From: Richard Mawdsley [mailto:rich_mawdsley@hotmail.com]
Sent: 01 October 2015 19:44
To: M4 Junction 3-12 Smart Motorway
Cc: info@louisamaxwell.com
Subject: 20150110_M4 Junction 3to12 expansion objection

I object to the application for the M4 Motorway (Junctions 3 to12) (Smart Motorway) Development Consent Order Application Reference Number: TR010019. I am an interested party by virtue of being a resident of Amerden Lane close to the motorway bridge.

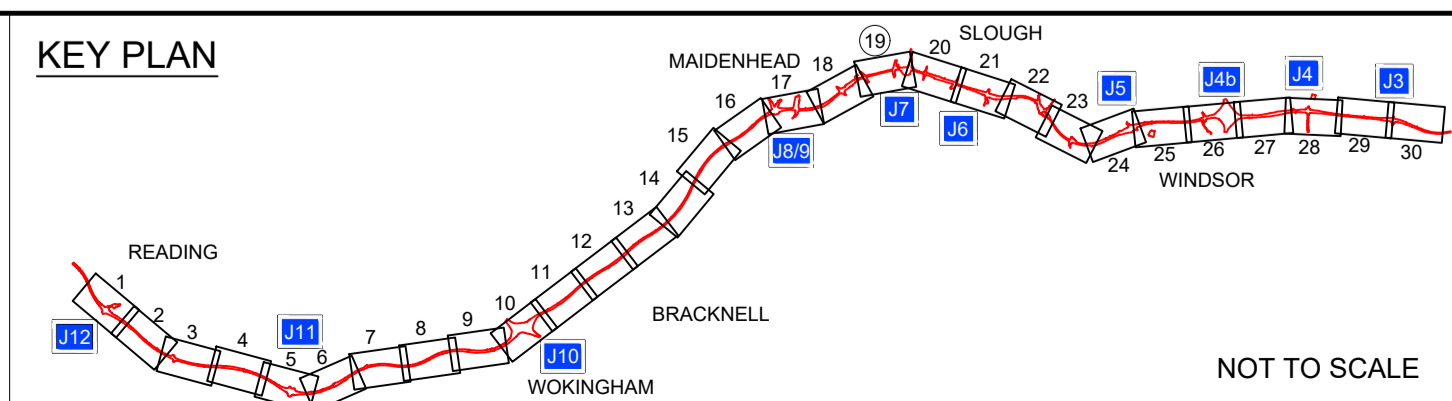
Removal of trees: To facilitate the new Thames bridge at Bray, the TPO protected trees and vegetation will be removed. These trees serve as a vital habitat for wildlife but also protect residents. The trees have many virtues in protecting residents from the effects of the motorway. Firstly, they are a direct barrier to sound and light pollution. Secondly, trees provide a filtering effect on some of the carbon gases released in car fumes. Other air pollutants also need consideration, particularly following recent research into diesel emissions. The following academic paper produced by the environment agency and county council highway departments details the effects of pollution close to the edge of the motorway (<http://core.ac.uk/download/pdf/62011.pdf>). The reduction in space between the edge of the motorway, and the local houses as well as the river should be of greater concern and should receive more consideration than is currently the case.

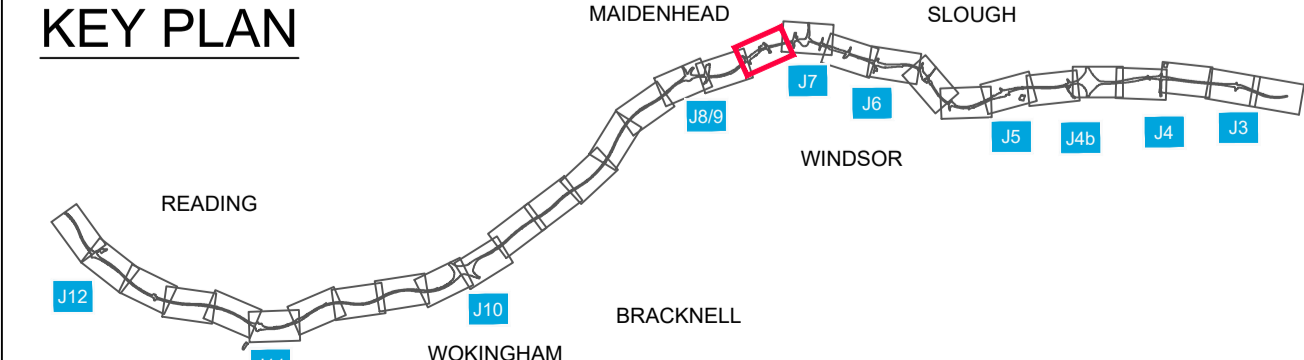
Land Plan Sheet 19 indicates that Amerden Lane will be used to access a new road for construction traffic which will impact on the residents and surrounding fields and wildlife. I believe that the use of Amerden Lane is ill considered. Amerden Lane (and before it, Old Marsh Lane) is a small single track road with few passing areas. Construction traffic may, just about, pass down the lane however, there will be no ability for local traffic to pass large construction vehicles, even at passing areas which are tight. This will inevitably lead to residents suffering significant disruption and upheaval as the current plan stands. No details of the extent of the works, dates of work or scale of traffic have been disseminated. Works must not start until provisions to reduce local disruption and discomfort are agreed.
